Our ref: WA/2012/113669/04-L01
Your ref: 12/00287/DISC
Date: 20 June 2013

Discharge of condition 68 of planning permission 10/01780/HYBRID. Revised plans

NW Bicester Eco Town, Caversfield, Bicester

Figure 3-5 Post-development extent comparison

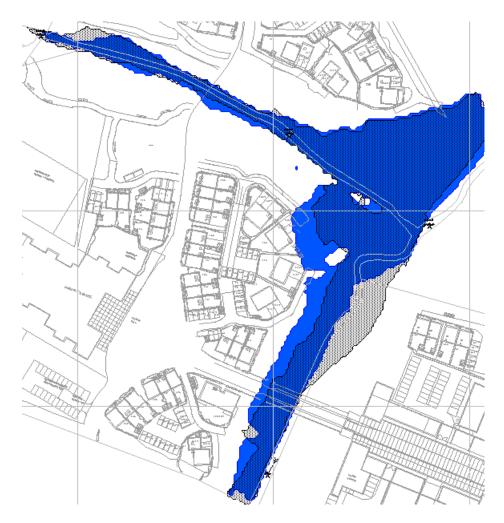
However, your Authority should be aware that Condition 68 requires a level for level floodplain compensation scheme which accords with section 3.5 of the approved Flood Risk Assessment (3501-UA001881-UU41R-03). This has not been provided. Instead, plans indicate some ground level raising within areas at risk of flooding, but these locations are thought to be within the tolerance of the hydraulically modelled extents and therefore effectively not at risk of flooding. We acknowledge that the accuracy/tolerances of hydraulic modelling mean that the actual flood extents may be smaller than those shown and therefore the areas of proposed raising may be outside flood risk areas. However, applying the same rationale there is an equal probability that the actual flood extents would be slightly larger than those shown and the potential loss of the floodplain storage greater than anticipated.
